CITY OF ALBUQUERQUE

December 15, 2017

RE: **Lot 17 Block 9 Unit 22, S.A.D. 228**
6427 Petirrojo NW
Grading and Drainage Plan
Engineers Stamp Date 12-6-17 (D10D003Q17)

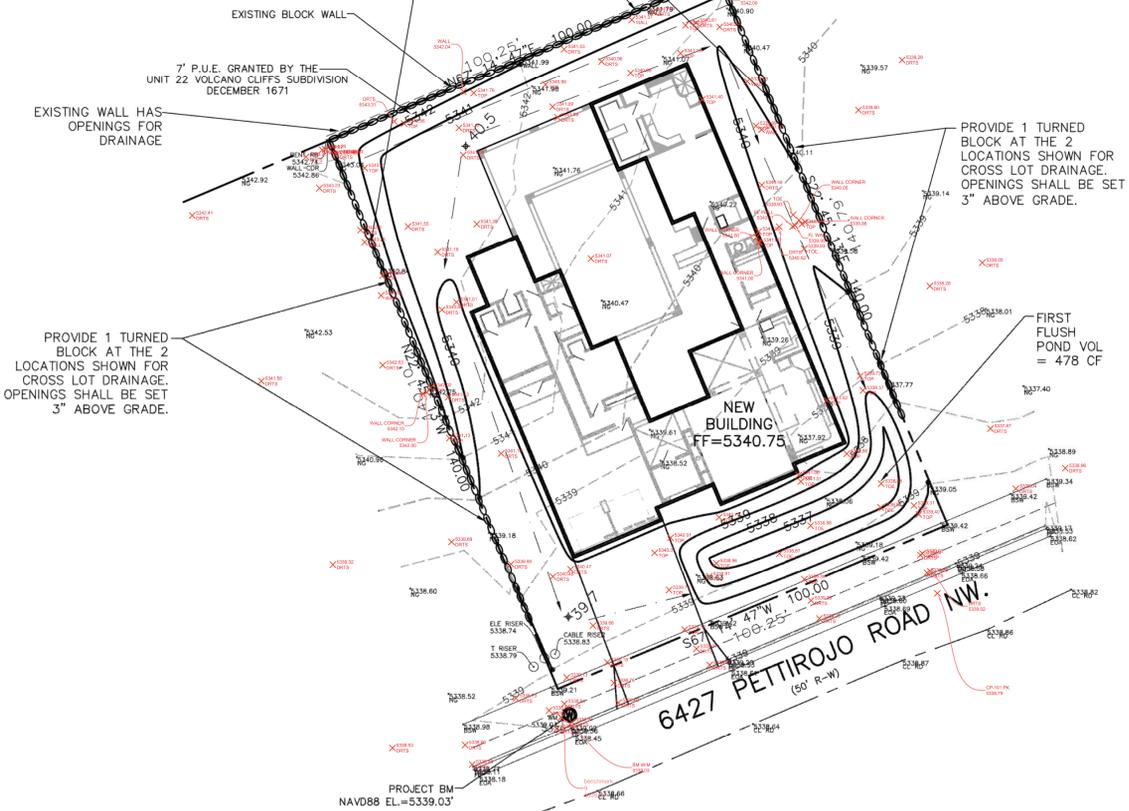
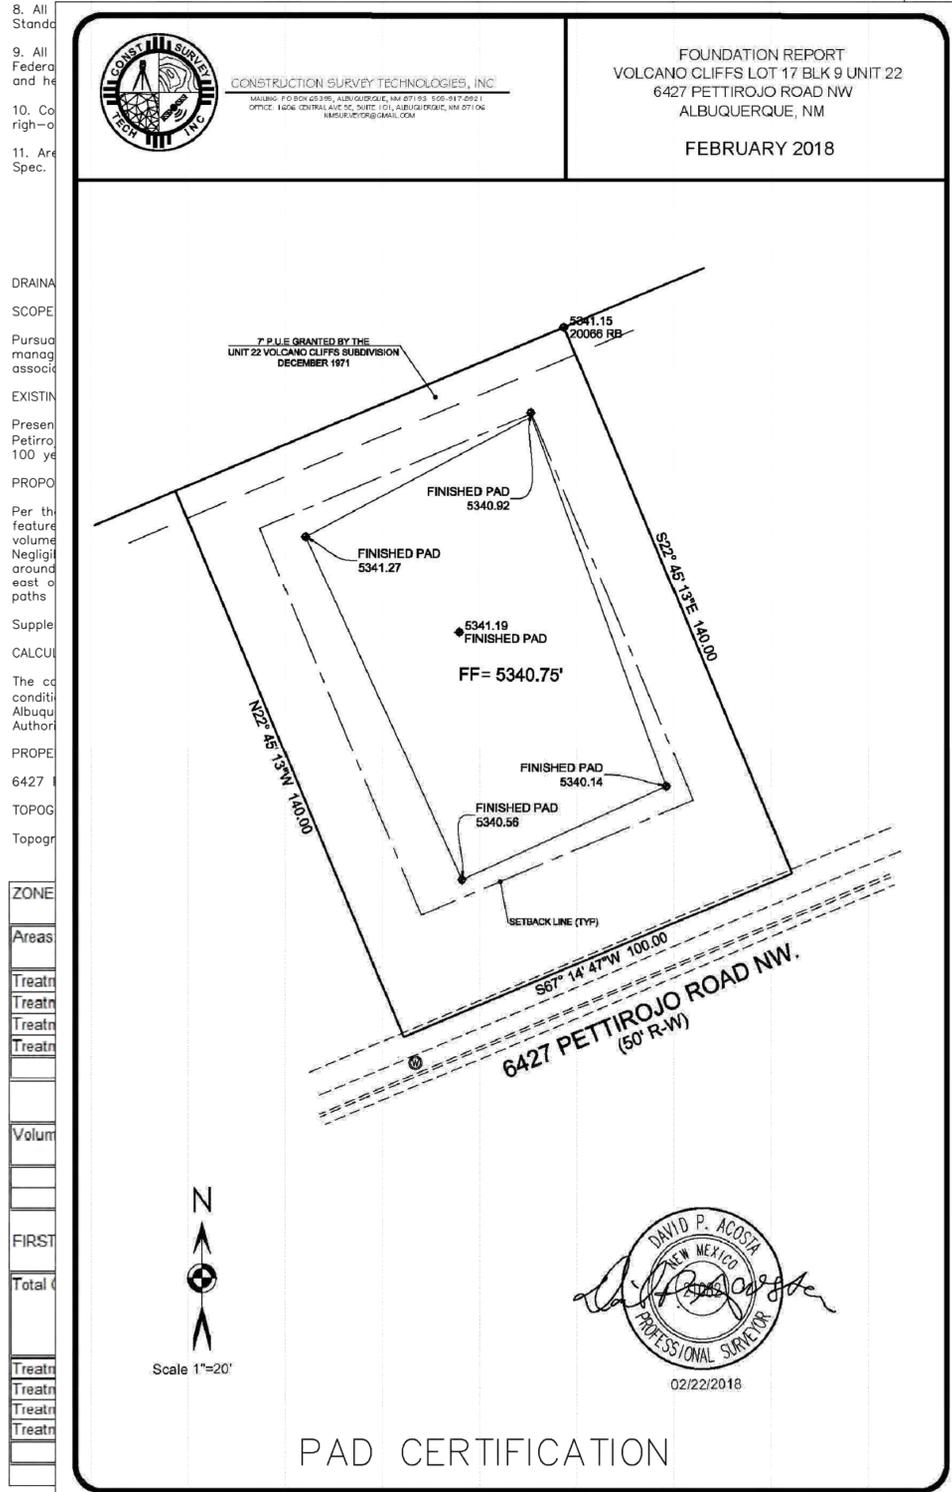
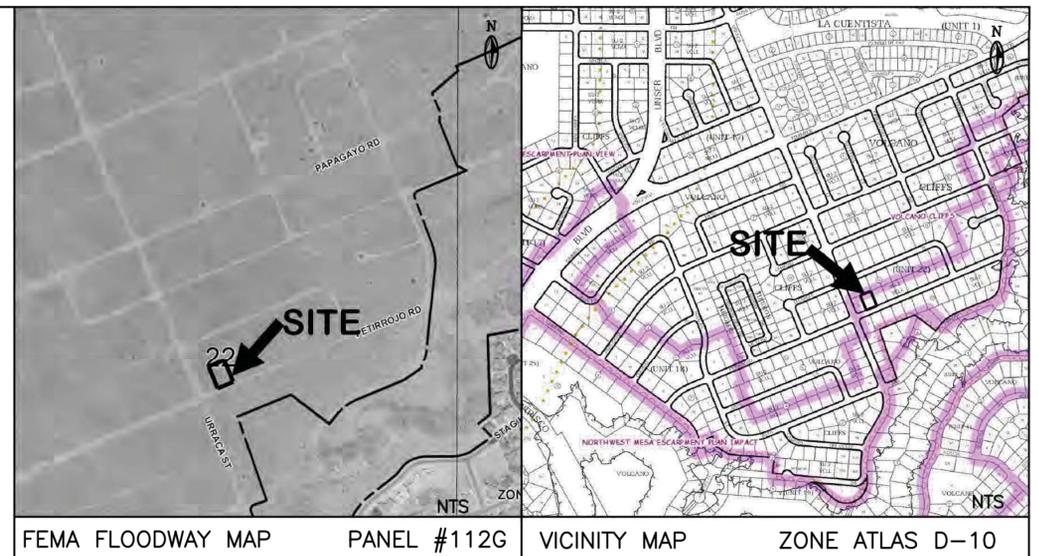
- Provide how the flows will enter and exit the rear yard from west to east. It appears the retaining walls will stop these flows.
- Provide the amount of flow entering and exiting the rear yard.
- Provide the size of the openings and calculations for the turn blocks, to show that the openings are sufficient for the passage of the flows required.
